Settlers View Subdivision
 Transportation Memorandum
 (LSC #164720)

RE: Settlers View Subdivision
El Paso County, CO
Transportation Memorandum
LSC #164720

Settlers View Site Plan

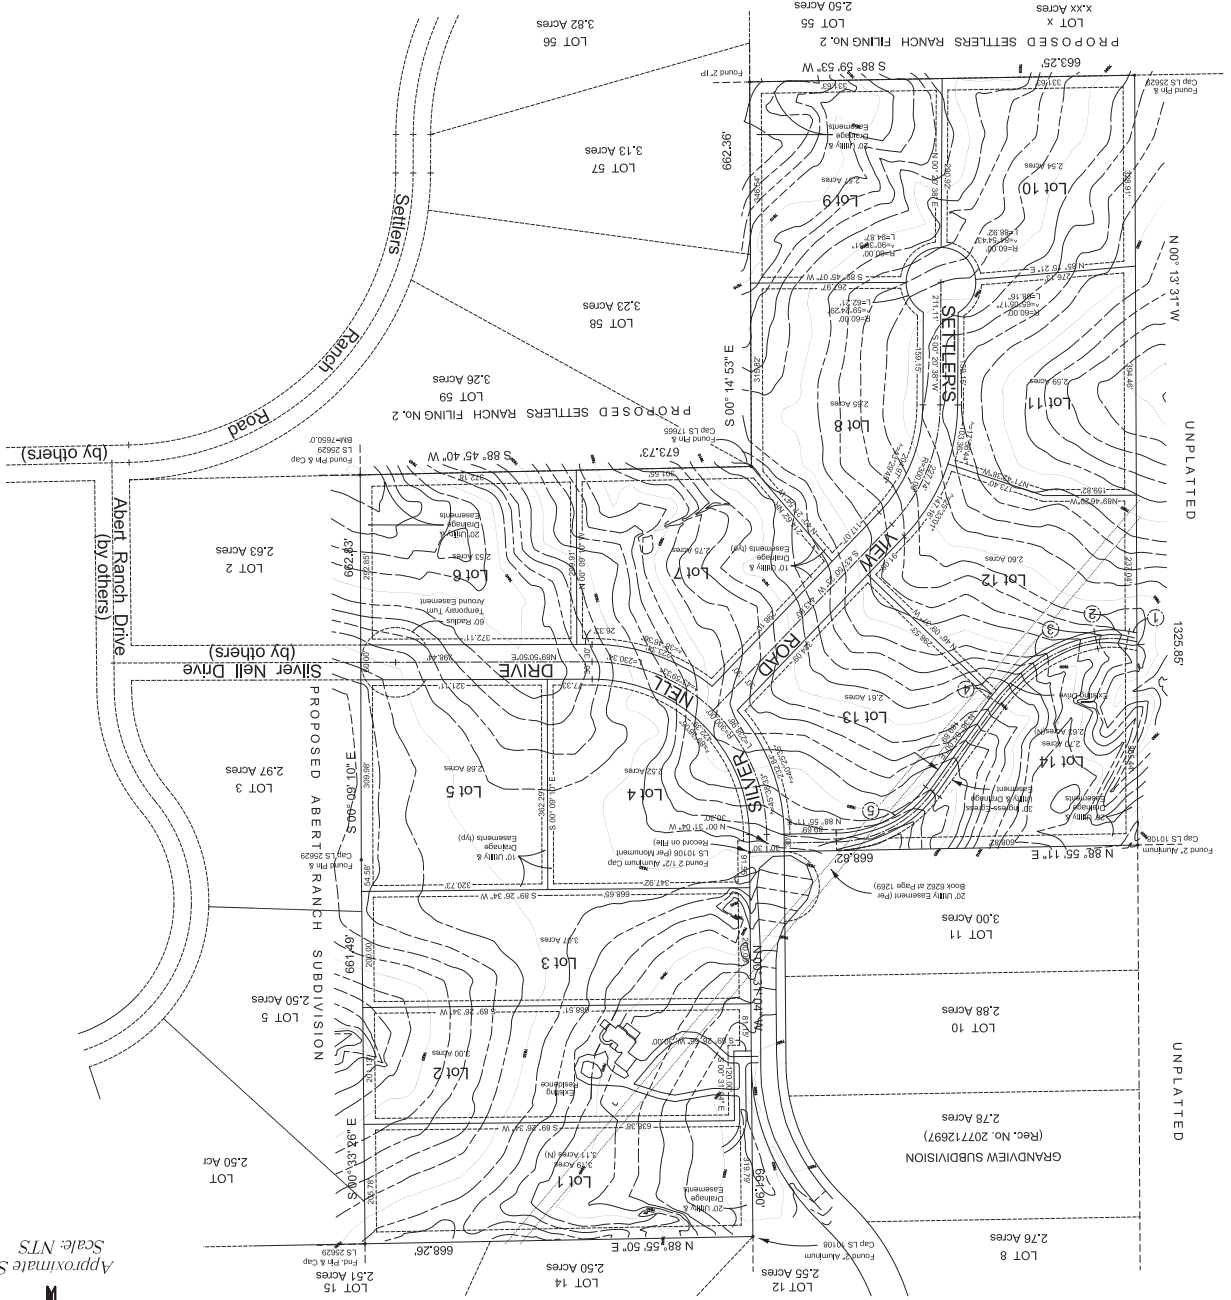
Submit a deviation request from the maximum length criteria for a cul-de-sac with the concurrent preliminary plan. The deviation must include a written endorsement from the Fire District.

Existing Traffic, Lane Geometry, Traffic Control & Level of Service

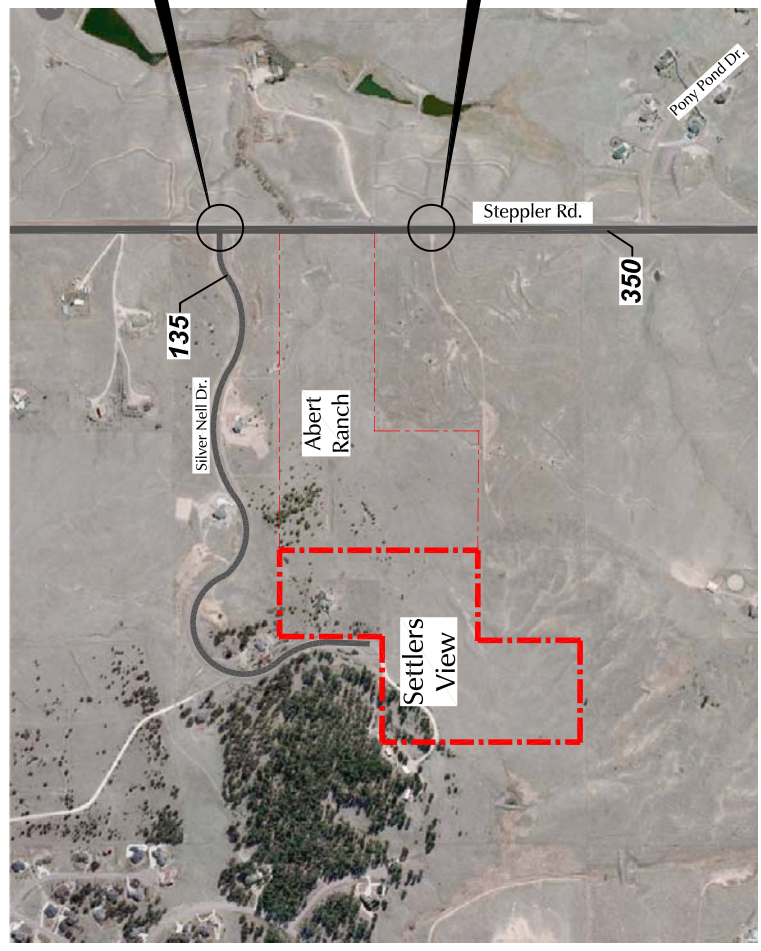
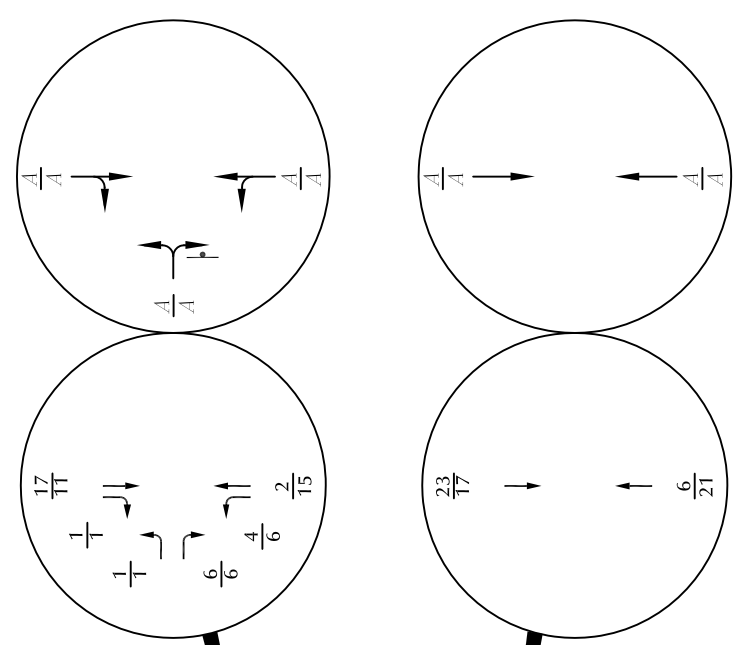
Provide a summary for Silver Nell Drive.
